Engineers Comments Regarding Surface Water Drainage

Application Reference:	BE/17/26/S73	Reviewer Reference:	ADC/EXT5/AF
Planning Officer:	Simon Brooksbank	Date of Review:	07/05/2026
Site Name:	Chalcroft Nurseries Land at Chalcraft Lane Bersted PO21 5TS		
Application Description:	Variation of condition 20 following approval of BE/148/20/OUT relating to rewording of condition.		
Assessment Number:	1

Site: **Nursery Fields, Bersted**
Title: **Site Phasing Plan**
Dwg No: **A437-DD-1000**

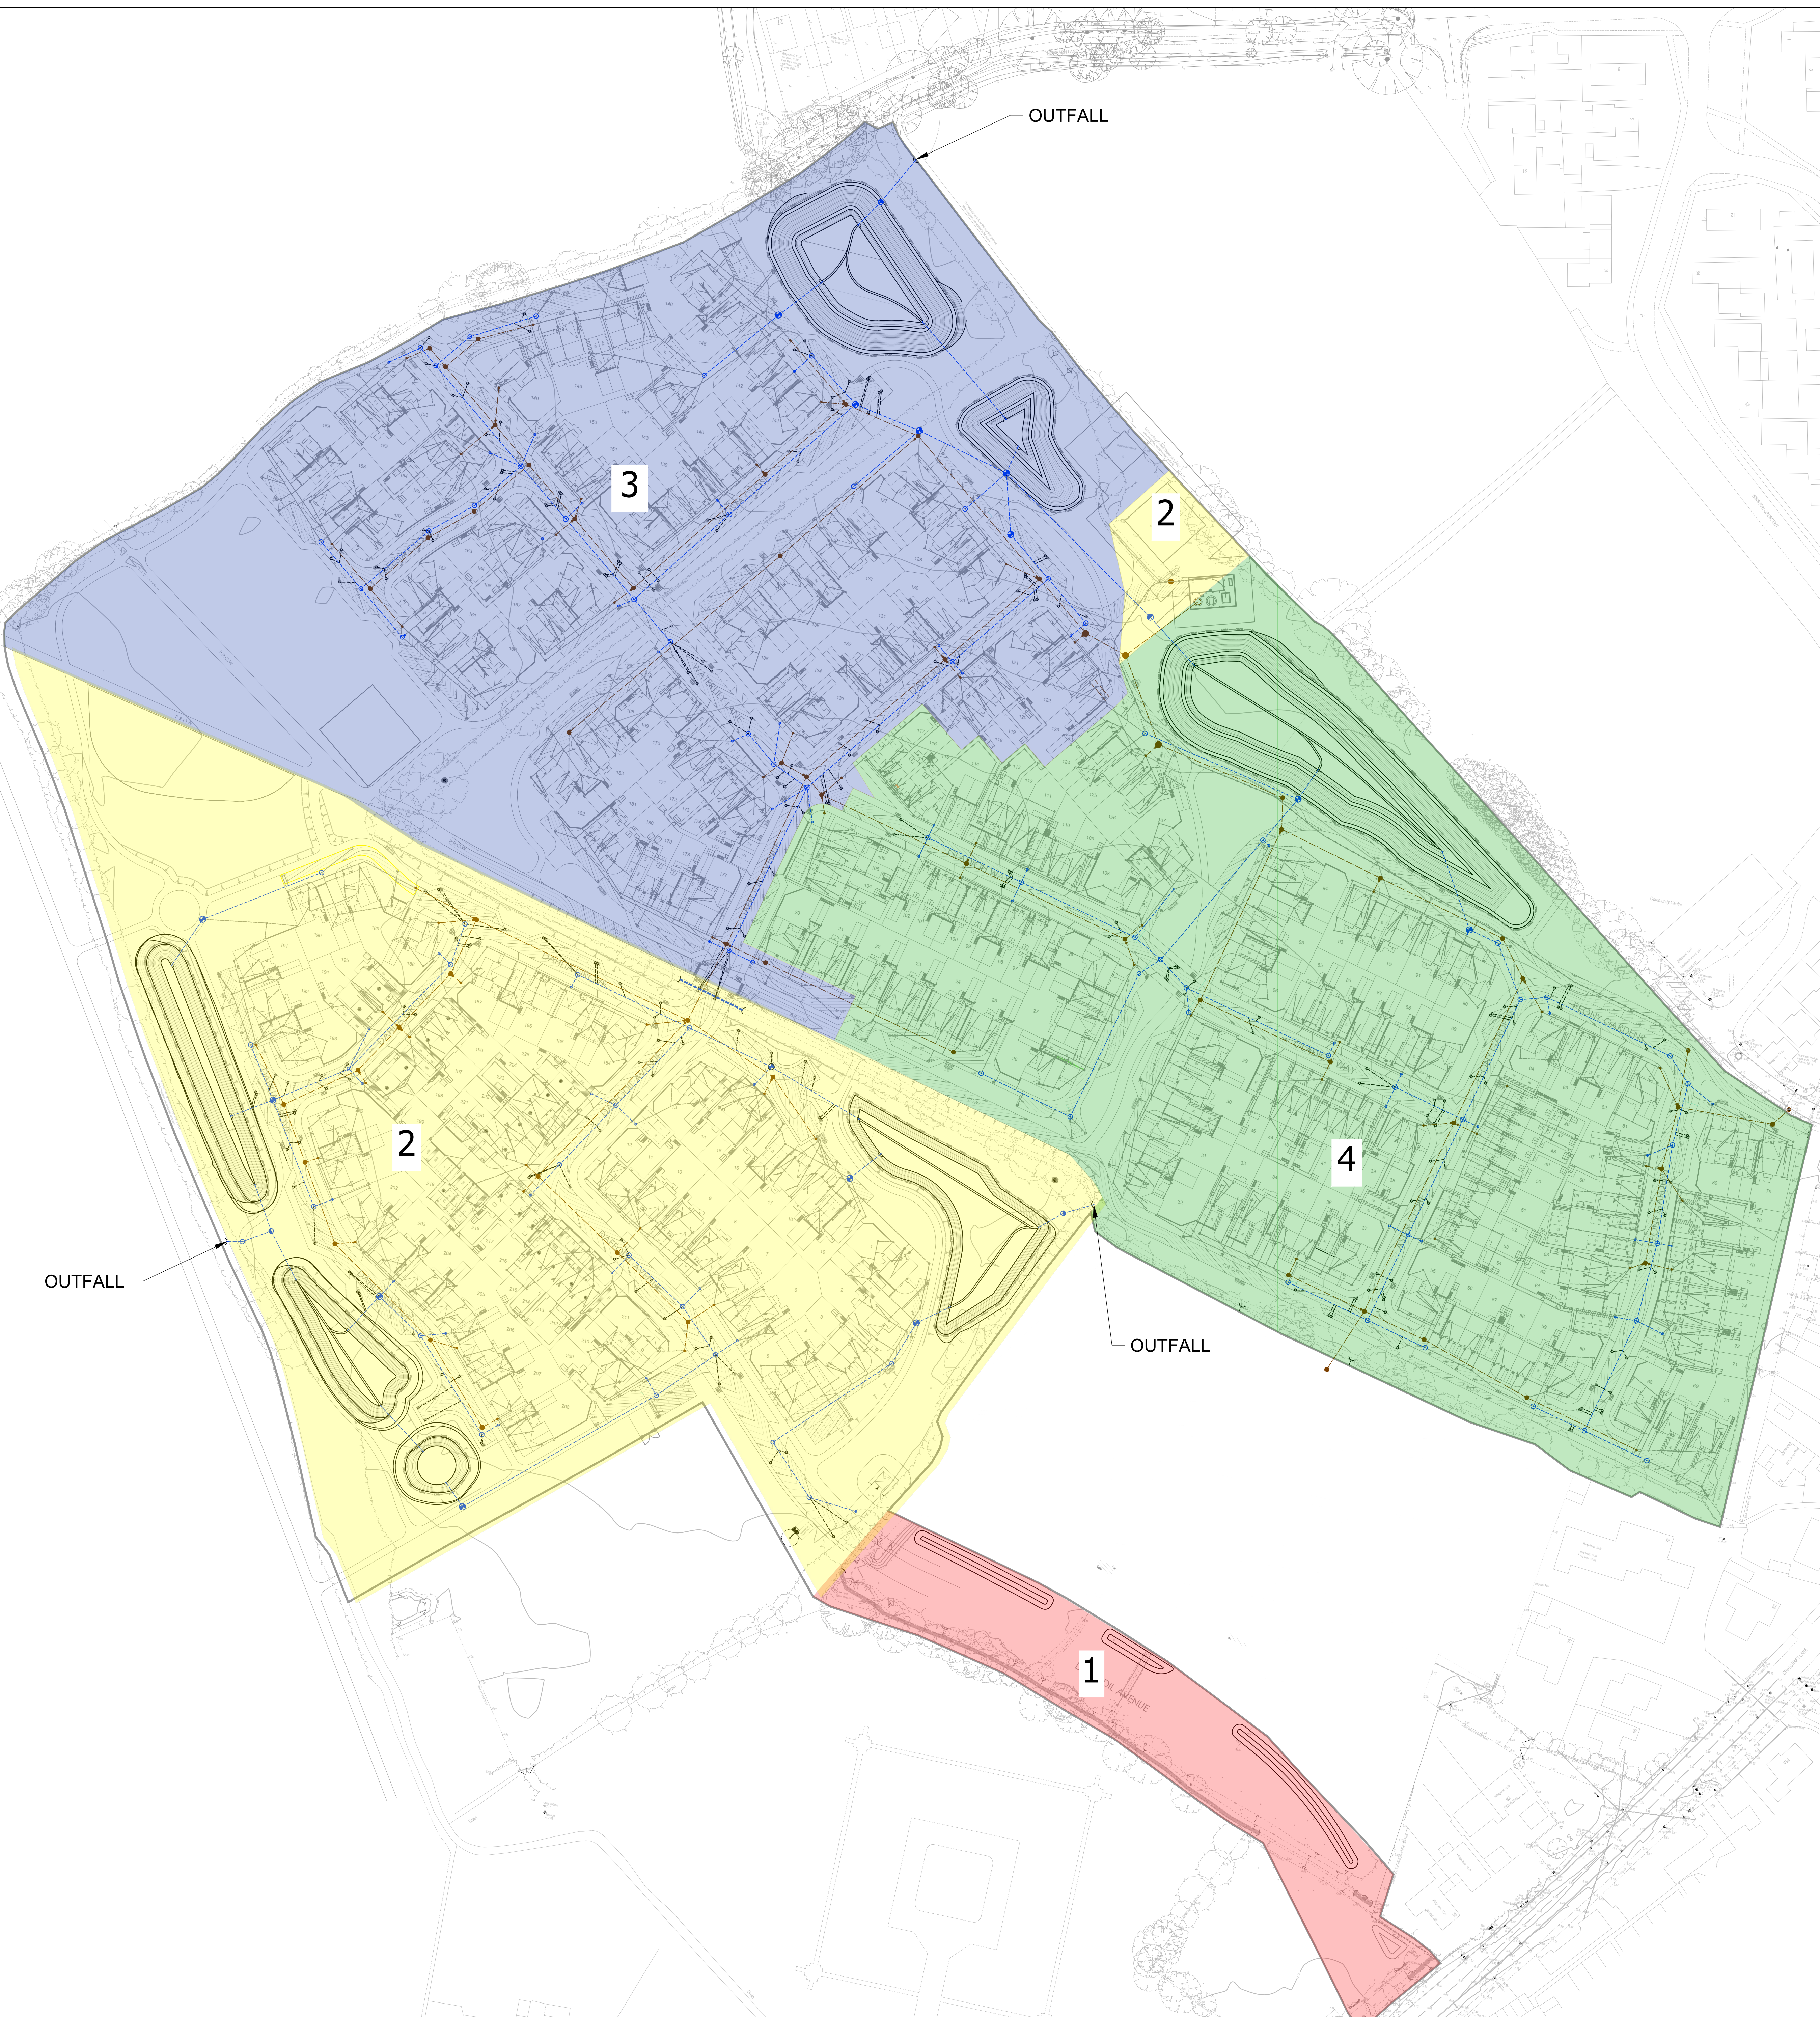
The principle of phased implementation and evidencing completion of the drainage system in accordance with the approved designs in a phased manor is acceptable but raises the risk of key infrastructure not being complete for a particular phase if outside that boundary.

We would wish to approve a phasing plan as part of this application to form the basis of the phased implementation and guarantee the infrastructure for each phase is in place prior to occupation.
